From: Daun Johnson
Sent: 20 December 2019 10:27
To: Planning Scanning
Subject: FW: Y/101/19/DOC - Yapton View (land off Burndell Road), Yapton, BN18 0HW

From: Kate Giddings <kate.giddings@arun.gov.uk>
Sent: 18 December 2019 13:09
To: Simon Davis <Simon.Davis@arun.gov.uk>; Planning.Responses <Planning.Responses@arun.gov.uk>
Subject: RE: Y/101/19/DOC - Yapton View (land off Burndell Road), Yapton, BN18 0HW

Thank you for the additional documents; the majority seem satisfactory but please may the applicant confirm whether the root membrane also acts as the visible deter-to-dig membrane (as per Geo-Environmental's RSVP) across this area of the site?

Site Photographs

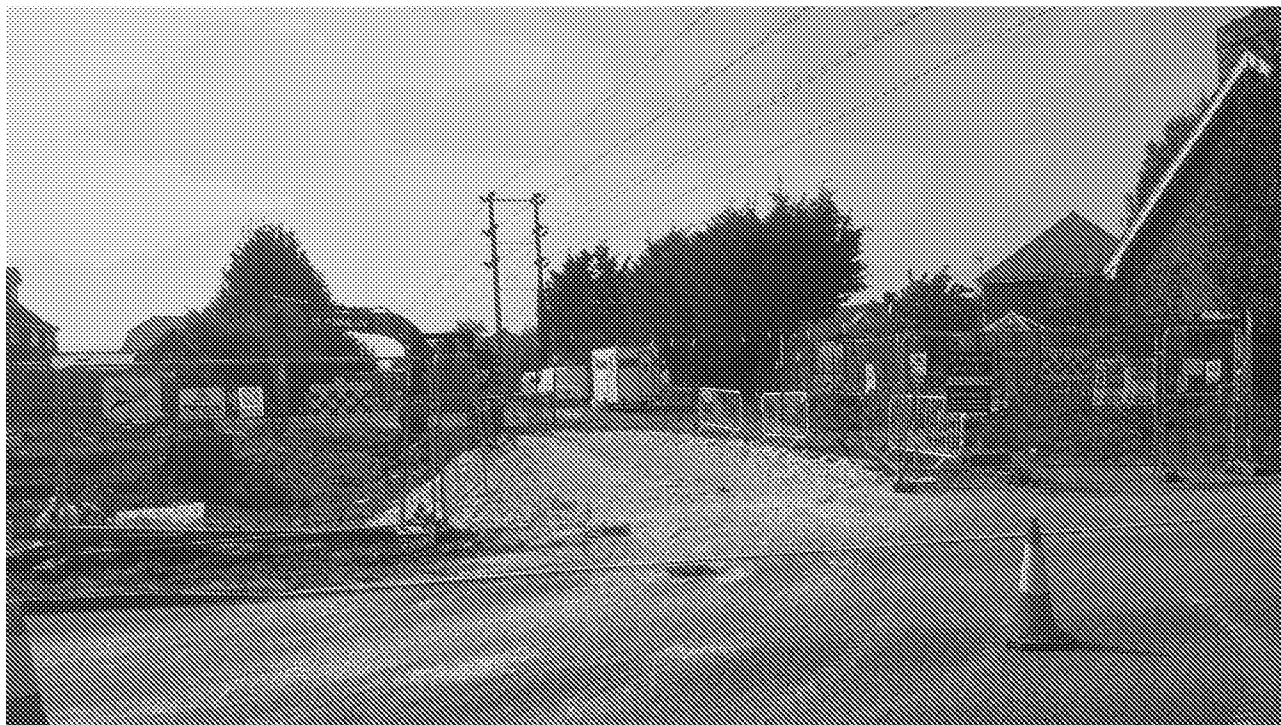
The three pictures in Appendix A do not appear to show the membrane or evidence imported material; please may photographs demonstrating the membrane installation at depth and copies of the transfer tickets for the imported material be provided.
